Subject: MidCoast Regional Organics Facility (SSD-84090218) (Mid-Coast)

Attachment 1 - CPHR Assessment Summary for Mid Coast Regional Organics Facility Environmental Impact Statement (SSD-84090218)

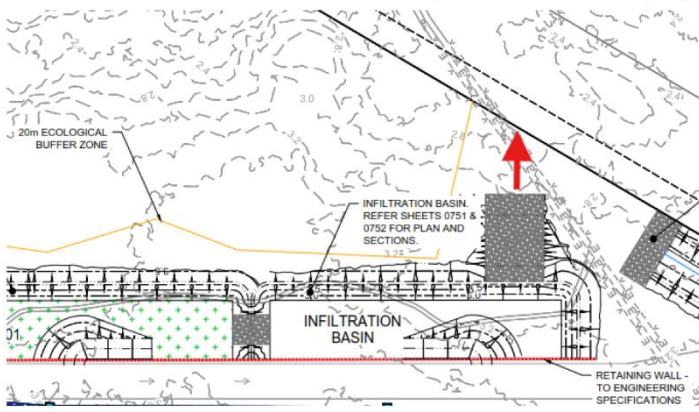
4.	<i>Unjustified land-use assumptions in water quality modelling</i>	<p>The MUSIC stormwater quality modelling adopts a combination of “forest” and “rural” land-use types to represent the pre-developed site condition. It is unclear whether the adopted parameters are supported by site-specific evidence or are aligned with the NSW MUSIC Modelling Guidelines (BMT WBM, 2015).</p> <p>Adopting inappropriate land-use assumptions can influence baseline pollutant loads generated by the model. Higher assumed baseline loads may make it easier for the development to demonstrate compliance with stormwater quality treatment targets, without accurately representing existing site conditions.</p> <p>Recommended action:</p> <p><i>Provide justification for the adopted pre-development land-use assumptions, supported by site-specific evidence.</i></p>
	<i>Extent and Timing</i>	Pre-determination
